REQUEST

Current Zoning: N1-A (Neighborhood 1-A)
Proposed Zoning: N2-A(CD) (Neighborhood 2-A, Conditional)

Approximately 7.96 acres located south of Sunset Road, west of Gutter Branch Drive, and east of Oakdale Road.

The petition proposes the development of up to 80 multi-family attached residential units, the site is occupied by one single family home.

Drawing file: approved-plans / 2025-048-siteplan-approved.pdf

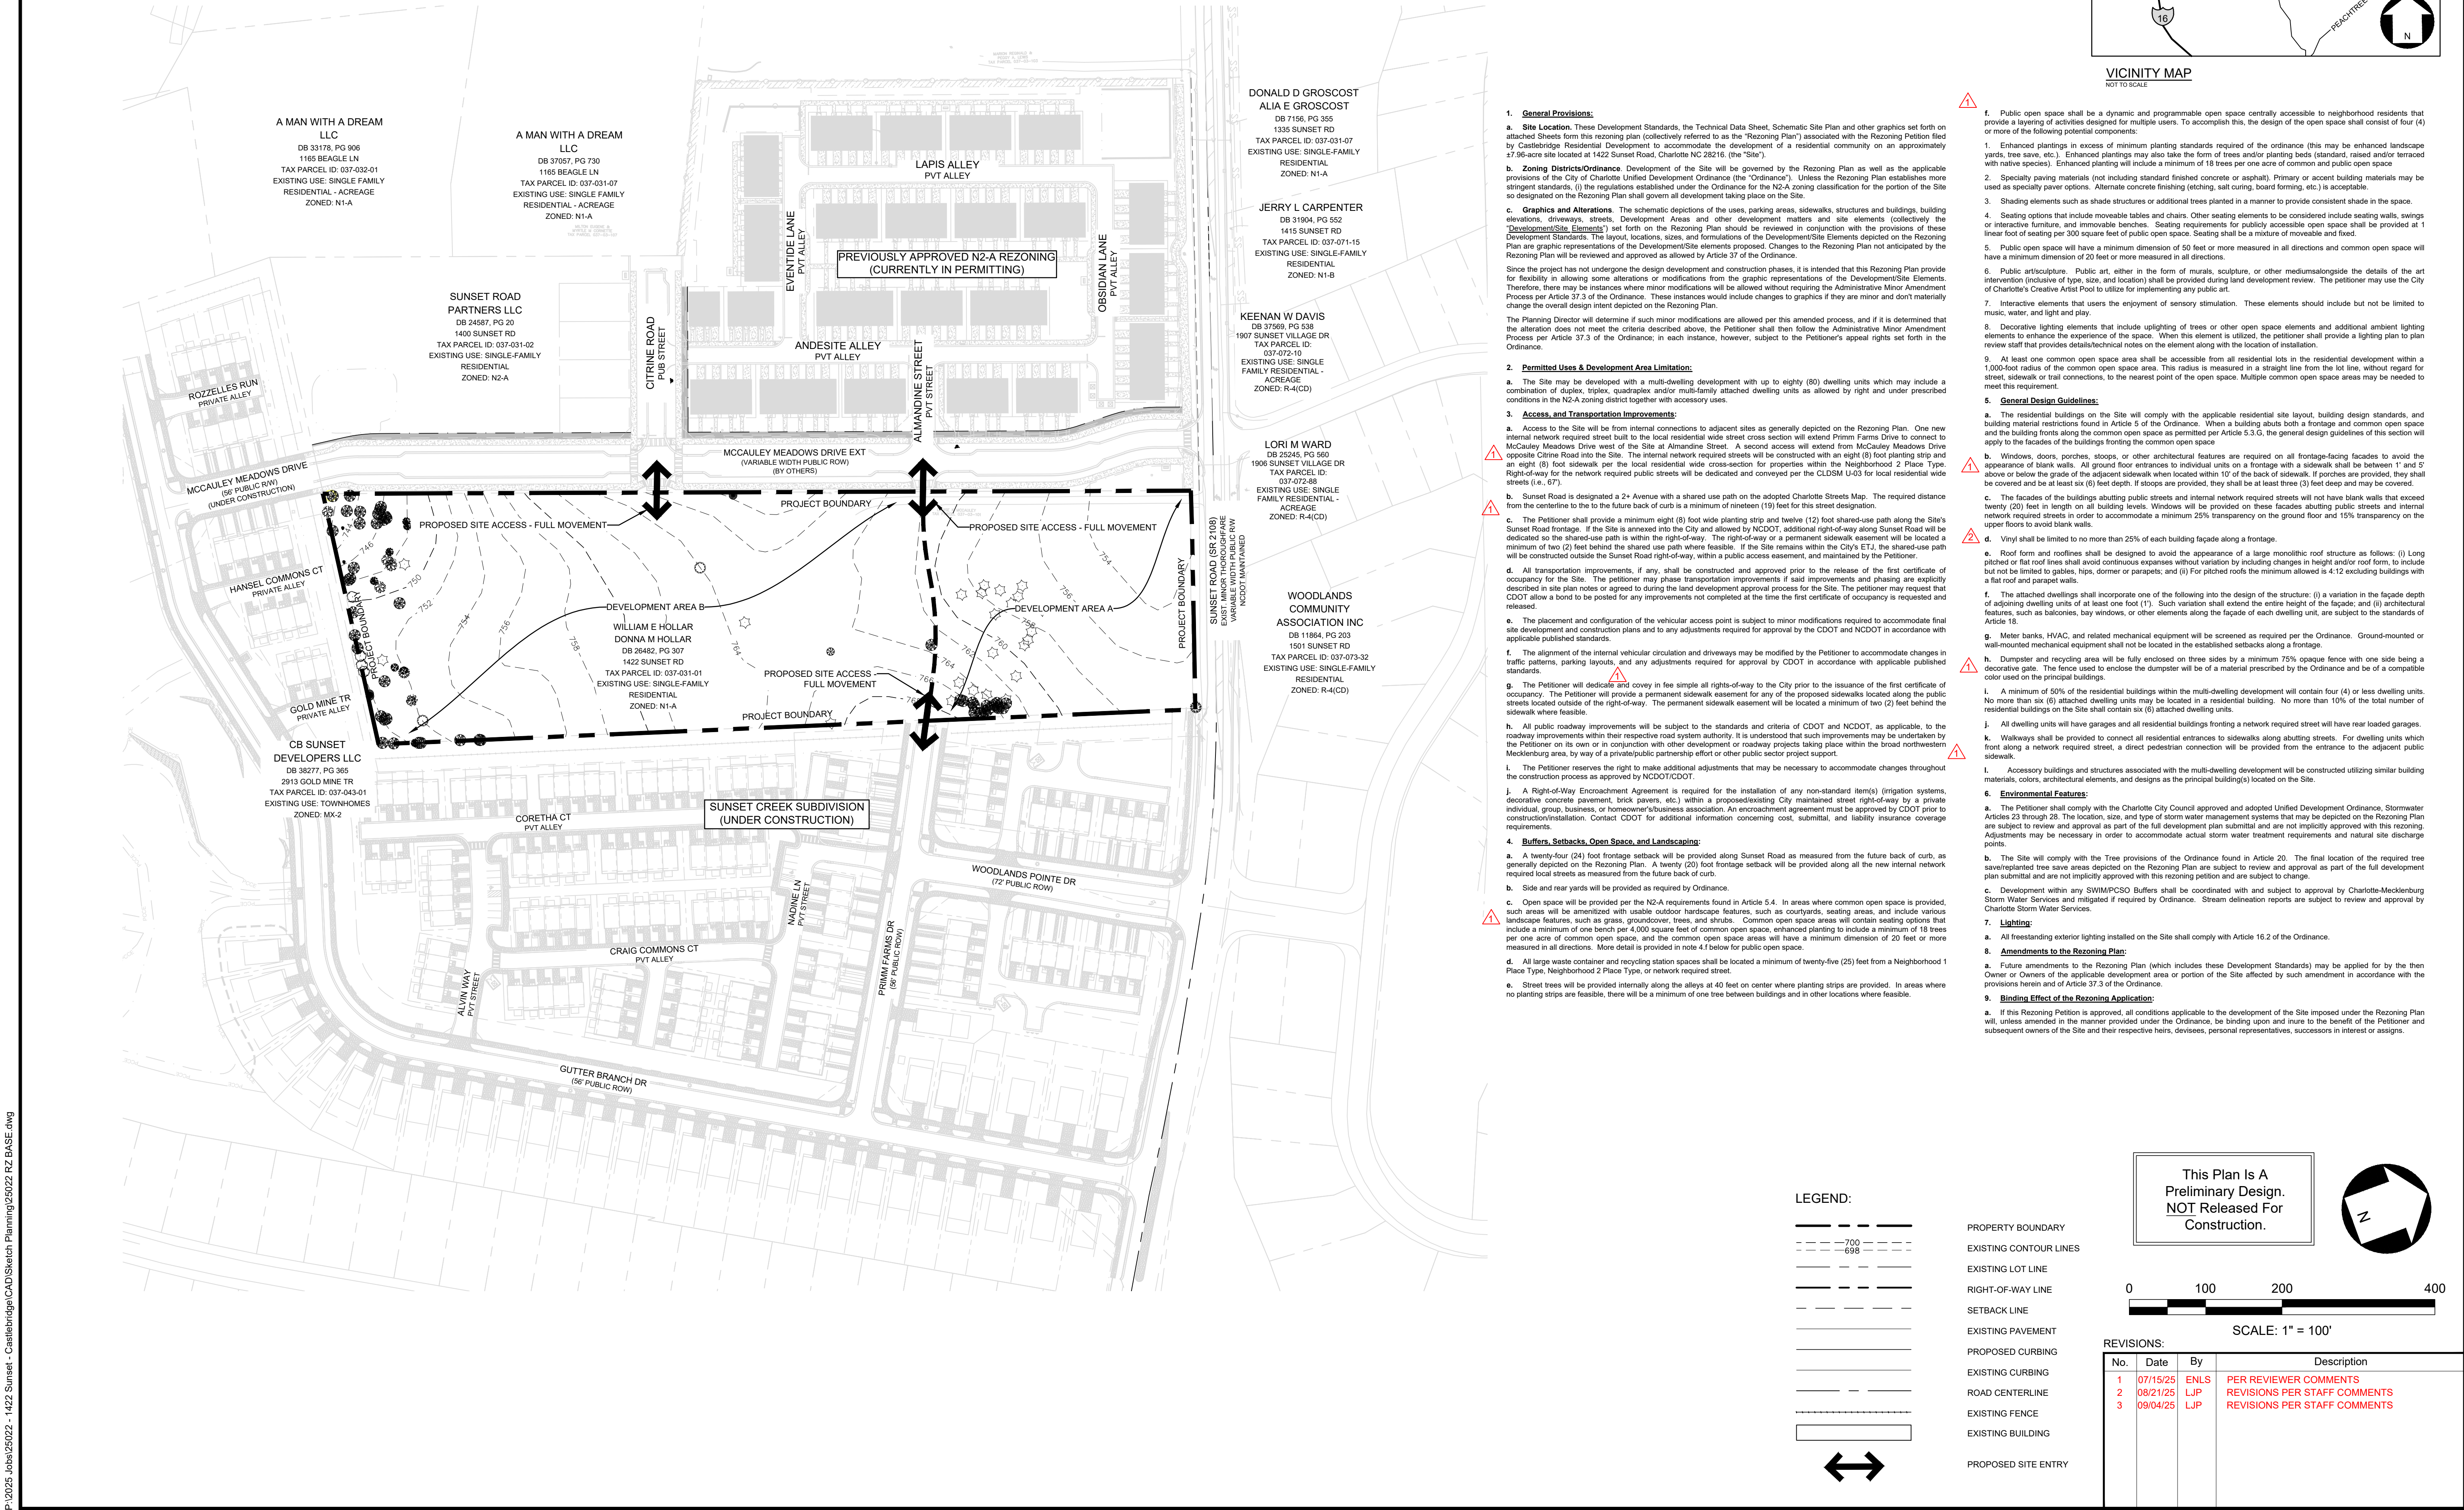
1. Solid waste facilities should be located at least 25' from property lines, see Article 21.4.A., confirm compliance and revise location shown on the site plan.
2. Revise architectural standards to just list prohibited building materials rather than preferred materials.
3. Add street trees along alleys and commit to maximum spacing.

4. Label and dimension the curb and gutter from the centerline for each road on the site plan.
5. Label and dimension what the future right-of-way of McCauley Drive will be.

RZ-2

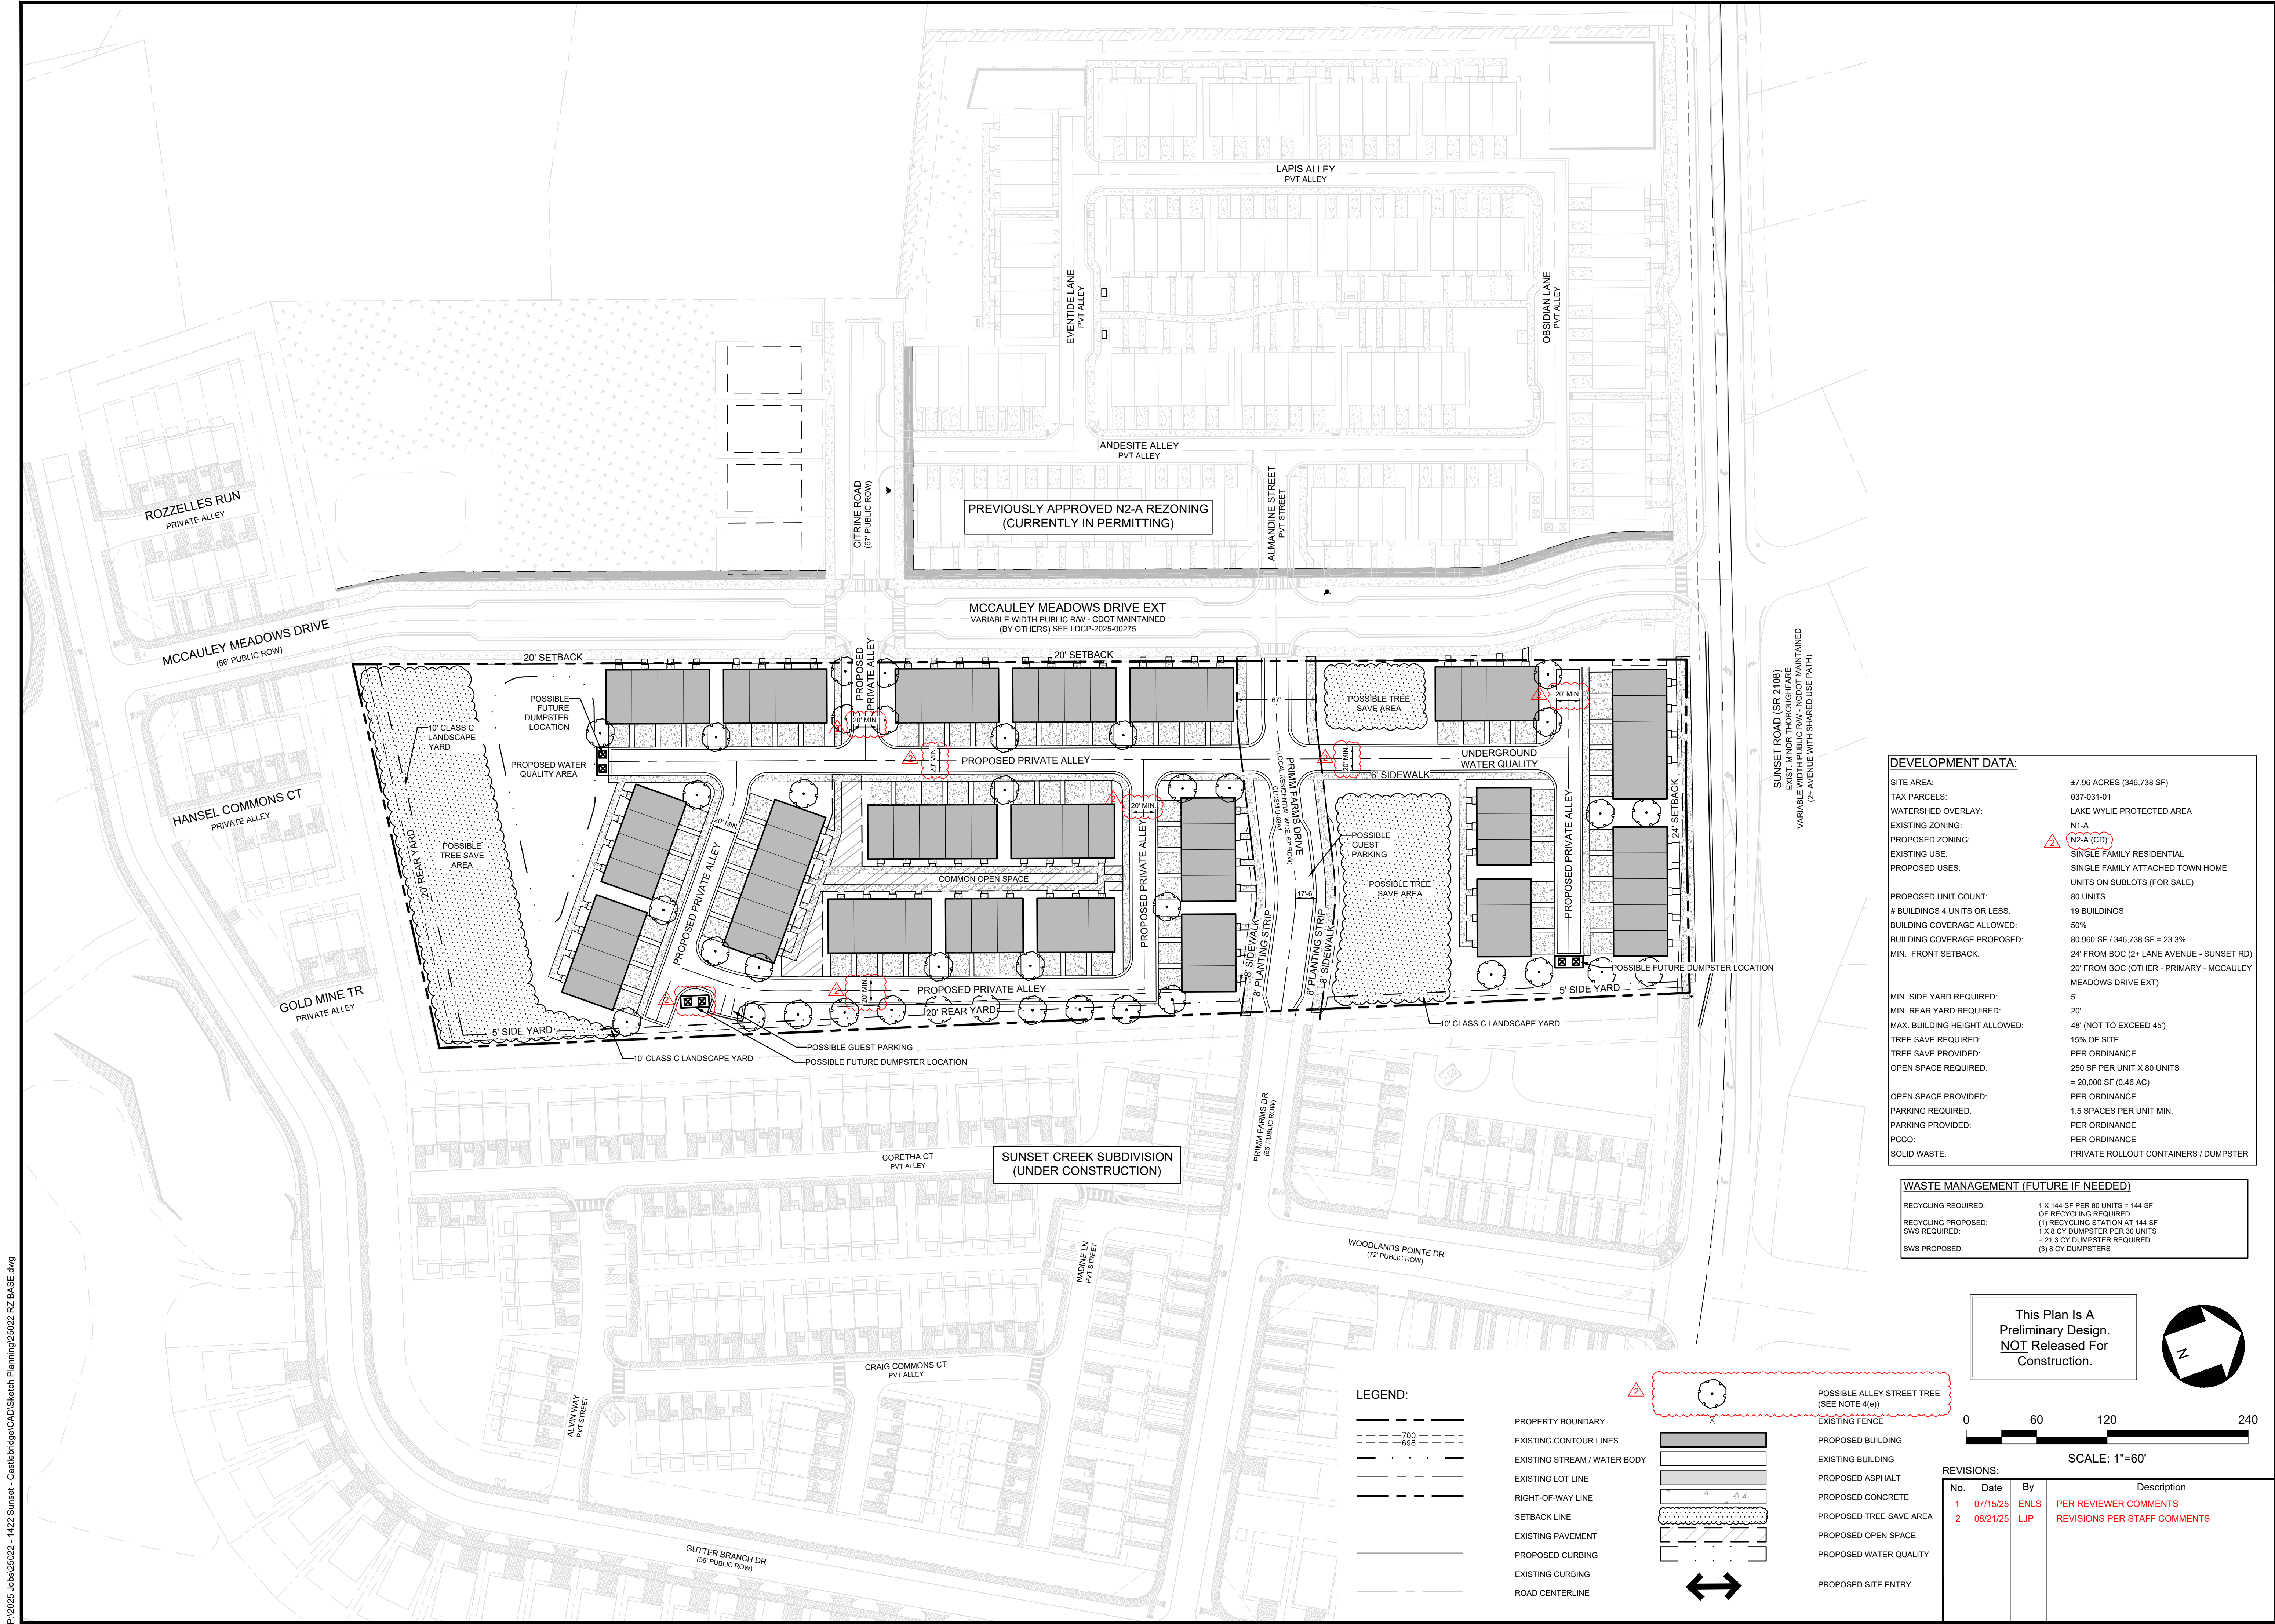
6. Revise development data table to list the proposed district as N2-A(CD).
